November 2, 2022

Re: **Report of Visual Observations**
Coble Farms – Lot 164
355 Hunting Wood Drive
Angier, North Carolina
GTA Project No.: 200385N164

SHEET NO.	<b>S-2</b>
MODEL	GEDAR
DRAWING TITLE	SECOND FLOOR JOIST LAYOUT
OPTION DESCRIPTION	
20

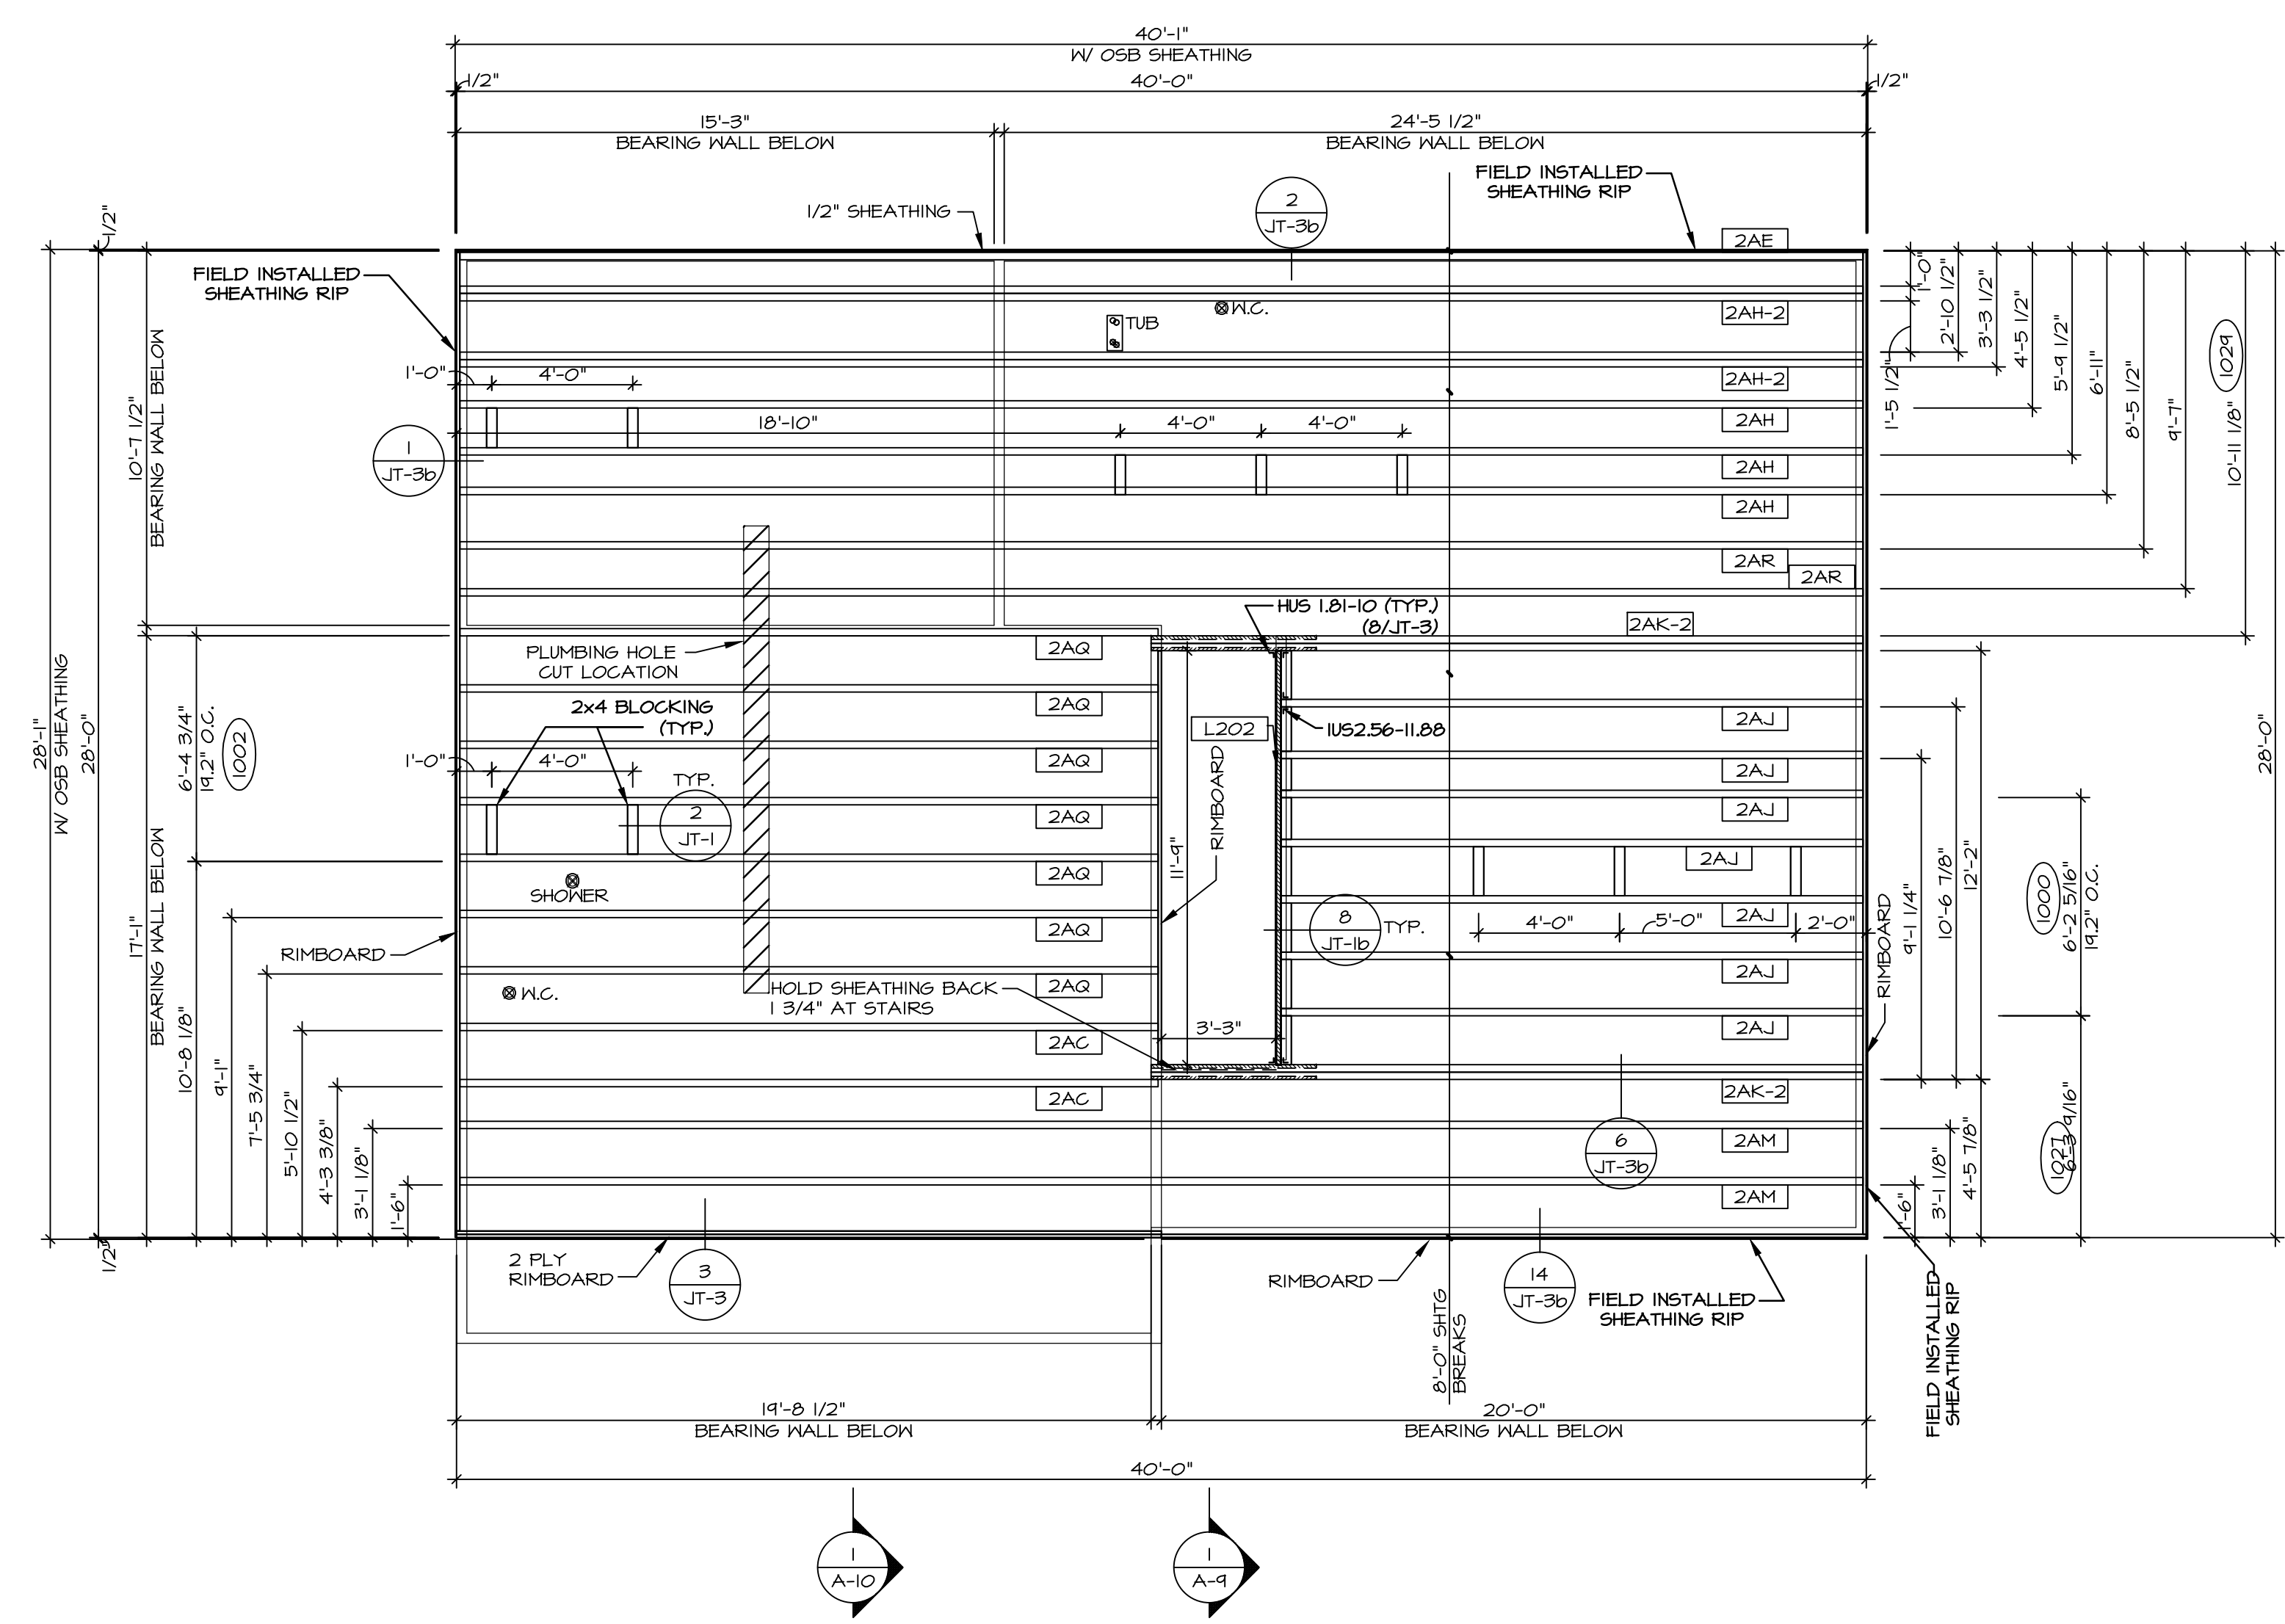
Pursuant to your request, GTA Associates, Inc. (GTA) is providing a summary of visual observation and recommendations regarding repair for framing concerns identified by the local building official at the residential home currently under construction at the above referenced address. Based on information provided by Ryan Homes representative Mr. Alex Brownlee, GTA understands the local building inspector has expressed concern regarding manufactured “knockout” holes in the webbing of TJI-joist with less than ¼-inch clear distance between the hole and joist top-flange

Based on the project information provided and based on the results of GTA visual observations during our site visit on October 31, 2022, existing prefabricated holes in the webbing of three (3) TJI-joist were observed to generally have less than ¼-inch webbing between the holes and joist top-flange. Please see the attached site photographs for reference. At the TJI’s prefabricated holes with less than ¼-inch webbing between the edge of the hole and top-flange, GTA recommends adding 2” x 4” blocking on each side of the webbing penetration, and on each side of the TJI, cut tight to fit between the top and bottom flange, and attached with 10d nails staggered at 4-inches on-center, for additional structural support.
